# **KITTITAS COUNTY**

## **DEPARTMENT OF PUBLIC WORKS**

### **MEMORANDUM**

**TO:** All Staff  
**FROM:** Public Works Plan Review Team  
**DATE:** December 27, 2024  
**SUBJECT:** SP-24-00015 Schmitt

SCHMITT SHORT PLAT

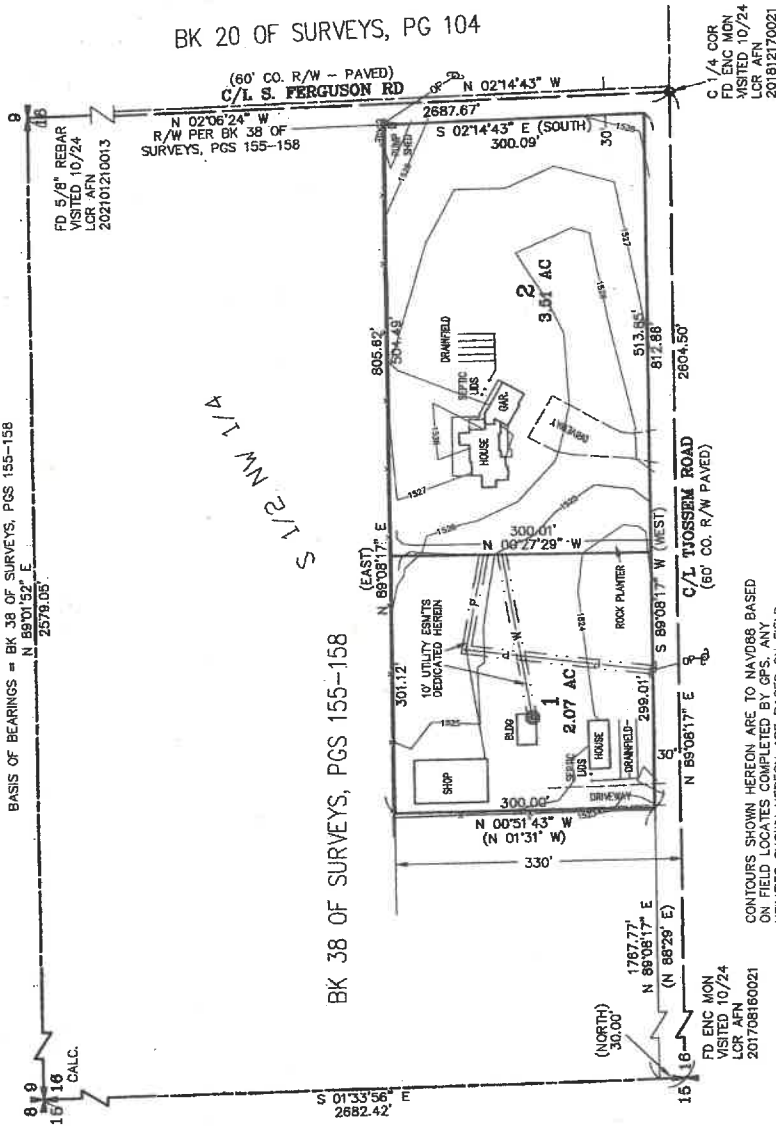
<b>ACCESS</b>	<ol style="list-style-type: none"><li>1. An approved access permit shall be required from the Kittitas County Department of Public Works prior to creating any new driveway access or altering an existing access.</li><li>2. Maintenance of driveway approaches shall be the responsibility of the owner whose property they serve. The County will not maintain private access.</li><li>3. Any further subdivision or lots to be served by proposed access may result in further access requirements. See Kittitas County Road Standards.</li><li>4. In addition to the above-mentioned conditions, all applicable Kittitas County Road Standards apply to this proposal. Access is not guaranteed to any existing or created parcel on this application.</li></ol> <p>OF NOTE: Lot 1 does not have legal access to Tjossem Rd. Under access/address permit # AC-17-00001; requirements were the address be changed to 4871 as the manufactured home was to be removed along with access to Tjossem. For the address to remain 4771 and the access to remain, please submit access/address permit to KCPW. Please ensure that Lot 2 is identified with the address of 4871 Tjossem Rd upon final recording of short plat. (KAH)</p>
